## **Stage 1 Road Safety Audit**

**Ballyfasy Wind Farm, Co Kilkenny**

On behalf of **Manogate Ltd**

**October 2025**

SITE ENTRANCE & VISIBILITY SPLAY Scale 1:250

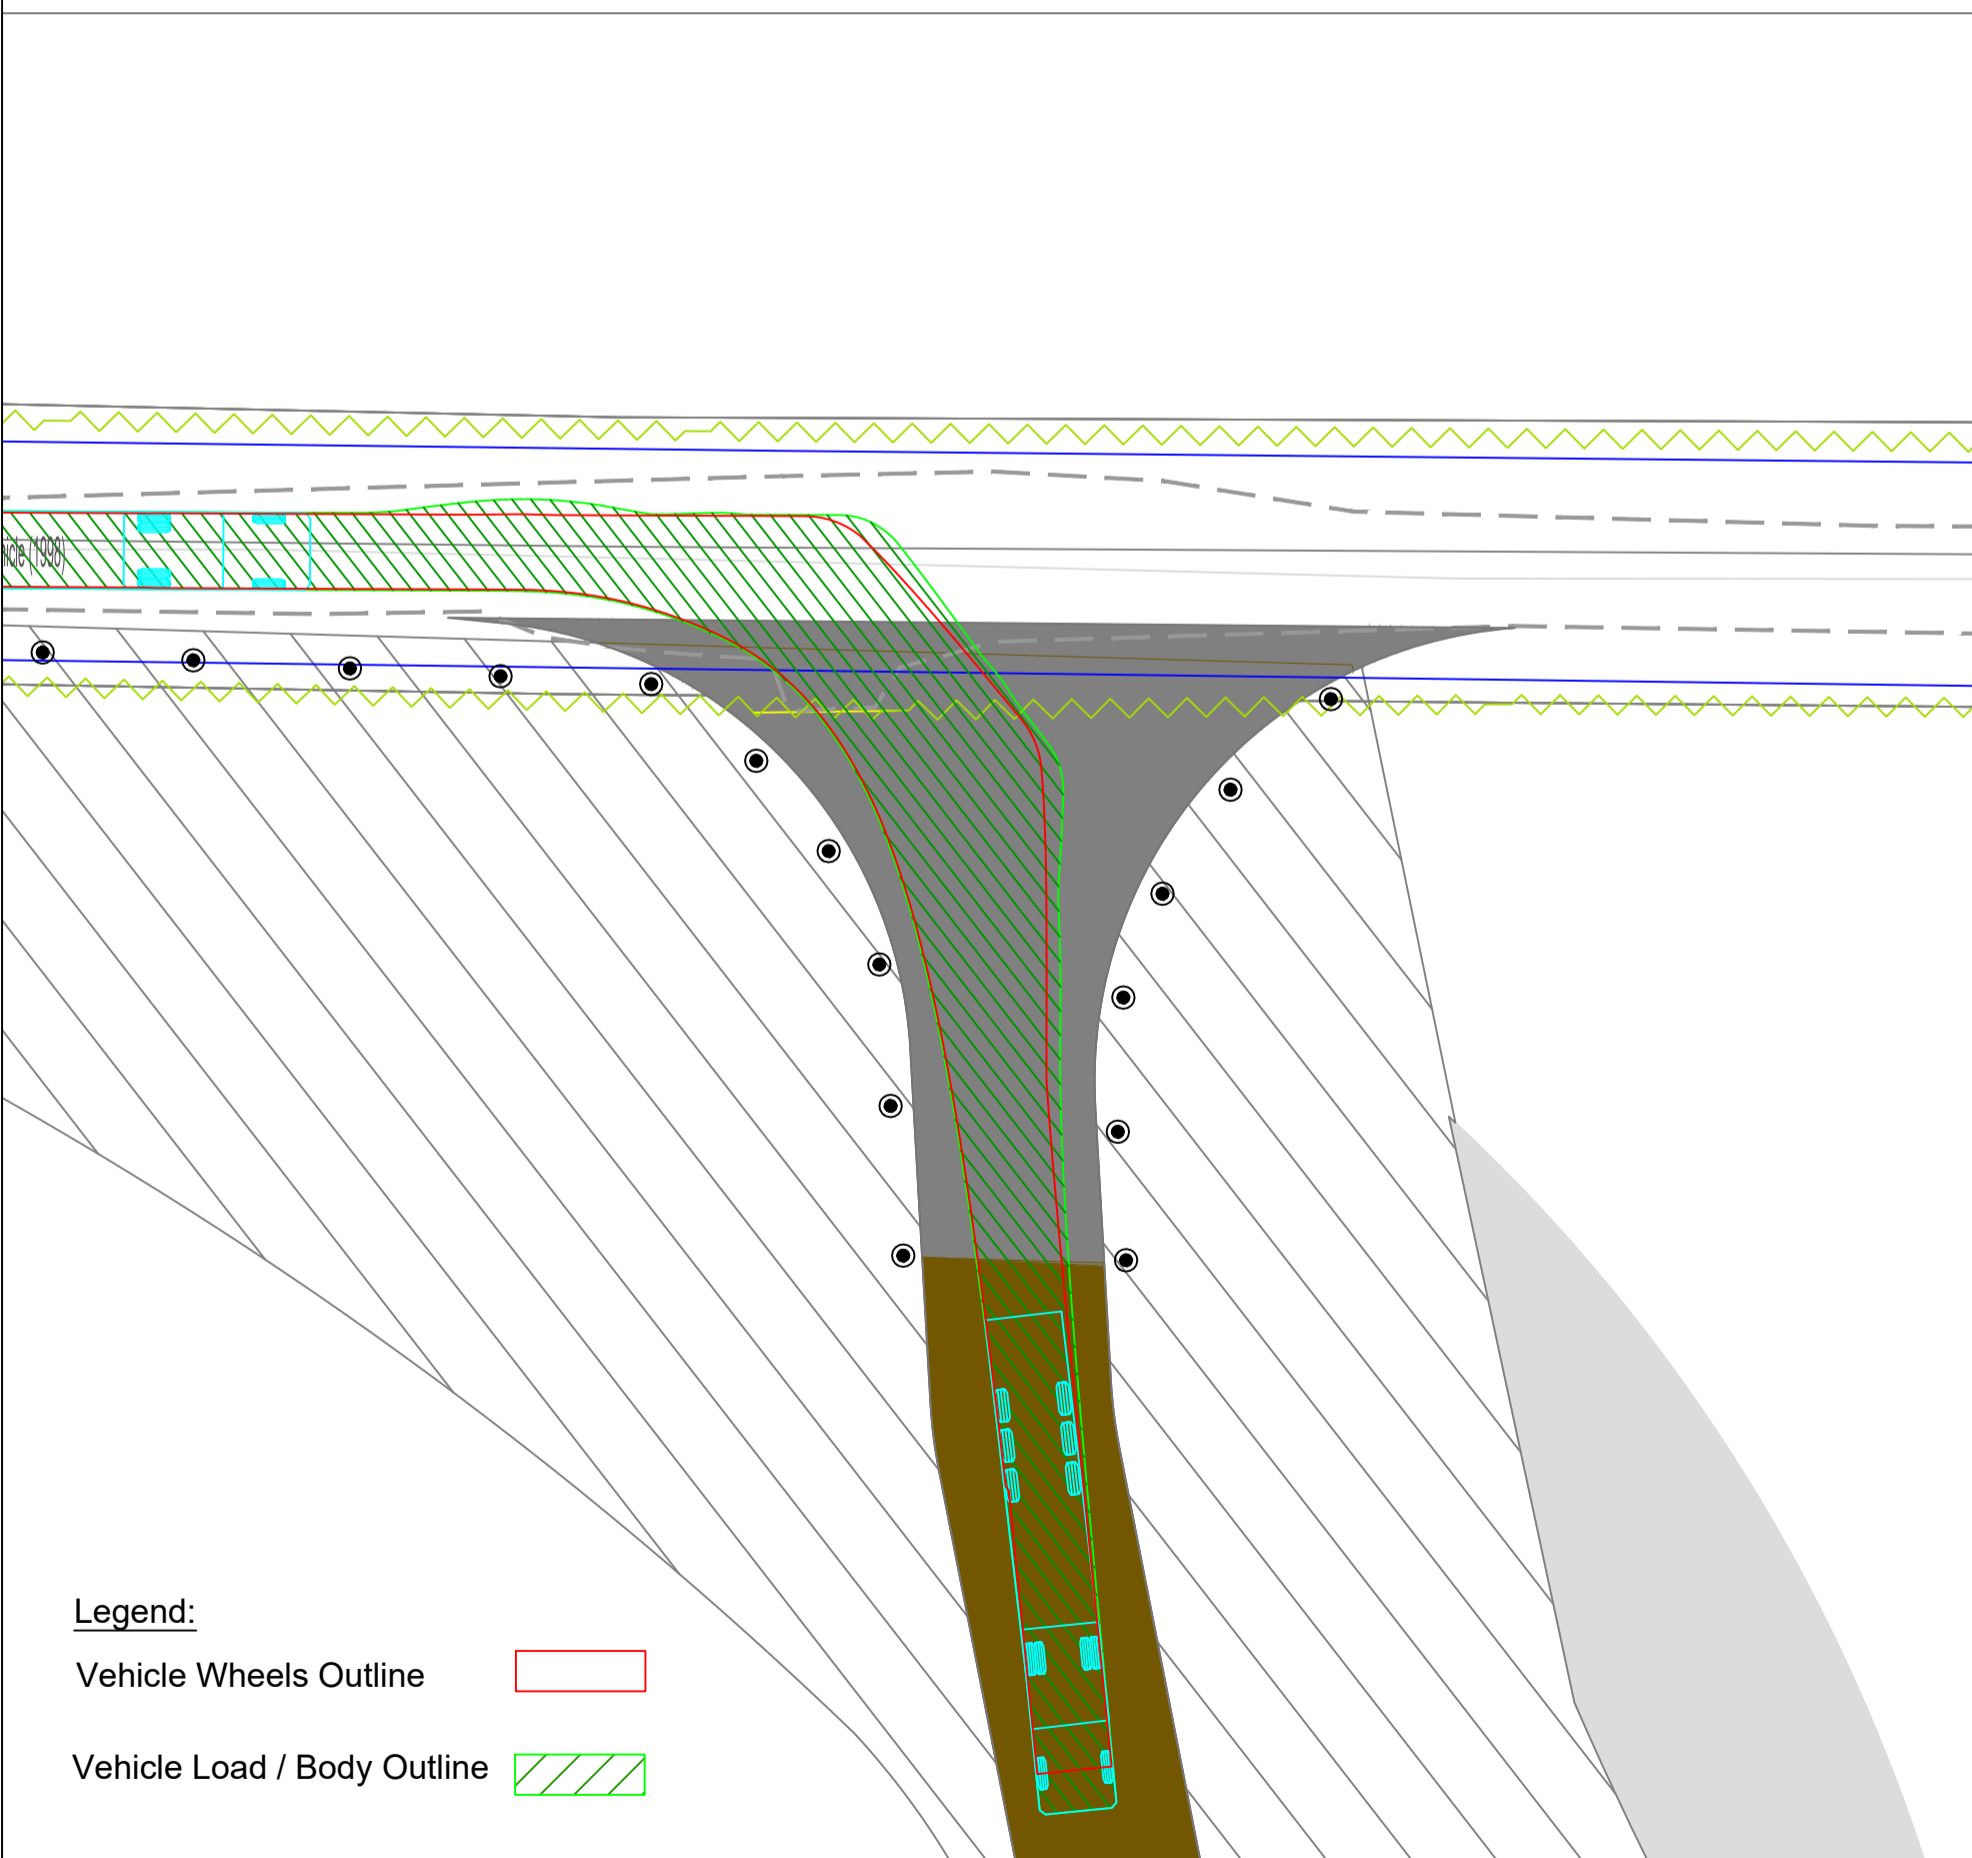
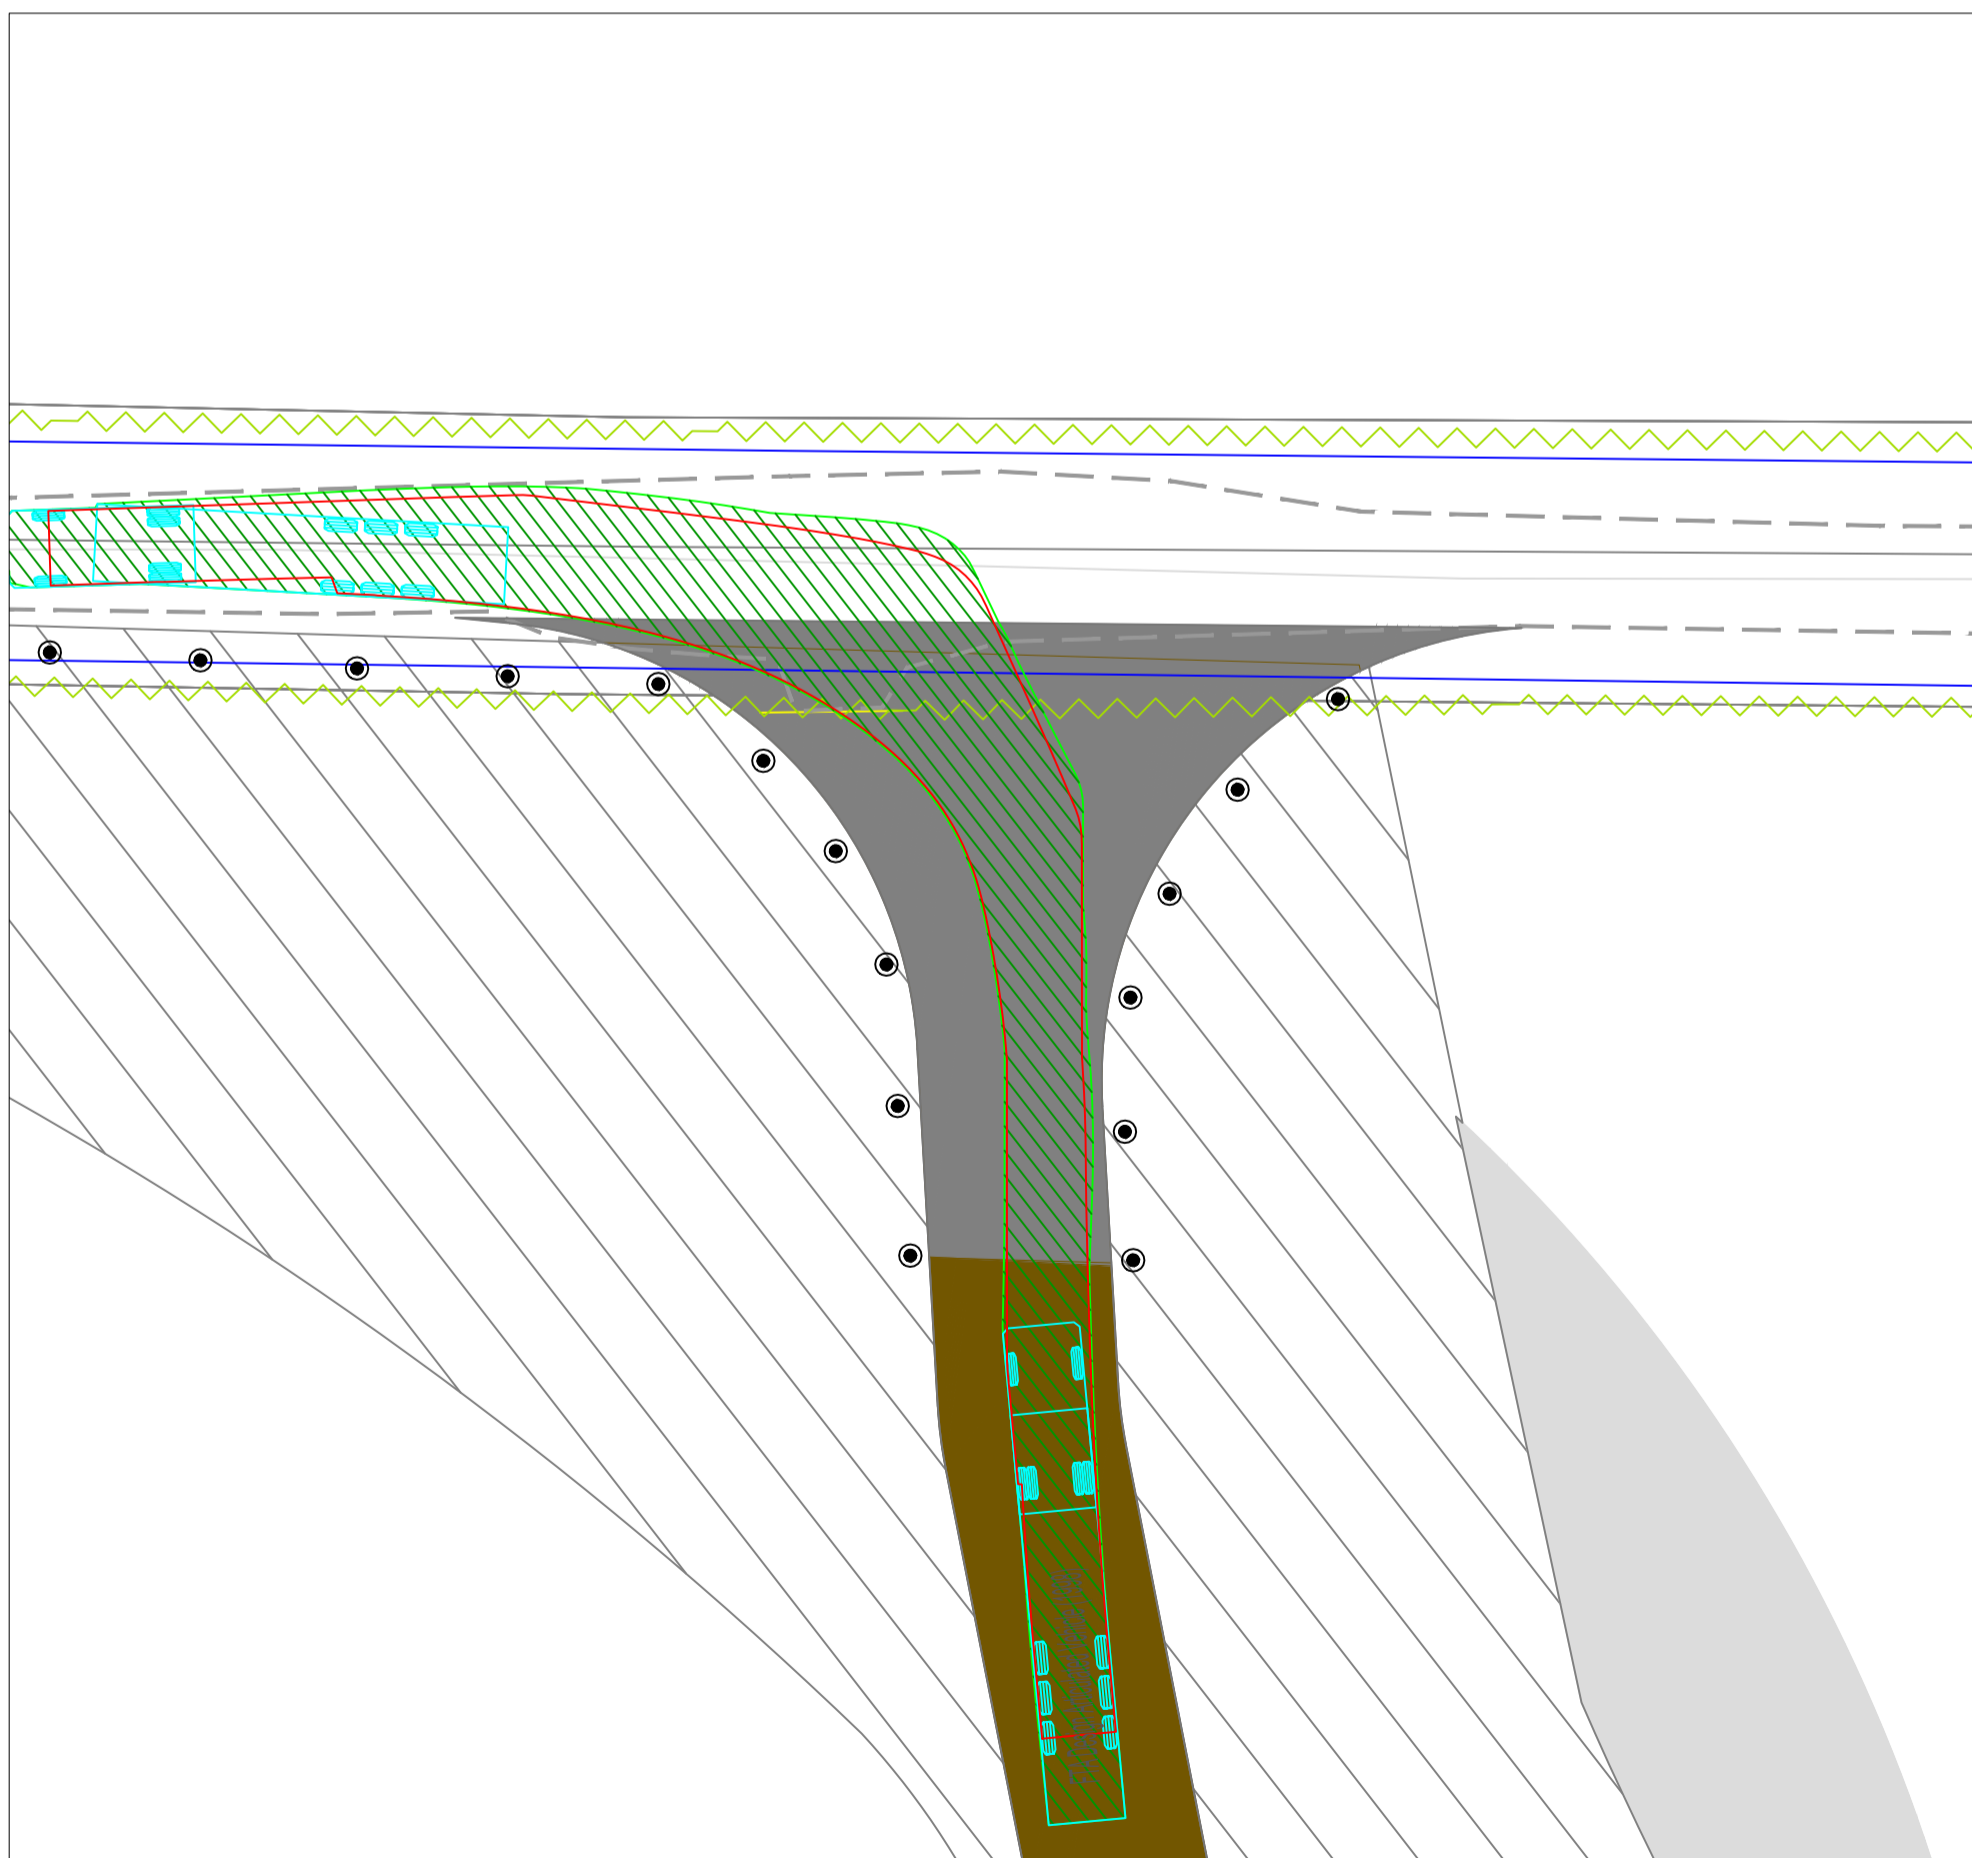
**Problem:** All junction visibility splays are indicated as 2.4 x 90m. During the site visit very few vehicles were observed and therefore it was difficult to estimate the existing vehicle speeds on these roads, however there is concern the visibility 'Y' distance is not suitable for the speed of vehicles on some of the roads.

**Problem:** There is a bend in the road to the west of the development junction. The dense vegetation / trees on the knuckle of the bend may impact with the required junction visibility envelope.

**Recommendation:** The Design Team should ensure the junction visibility splays are appropriate for the public road traffic speed.

**Recommendation:** The Design Team should ensure suitable junction visibility splays are provided and maintained.
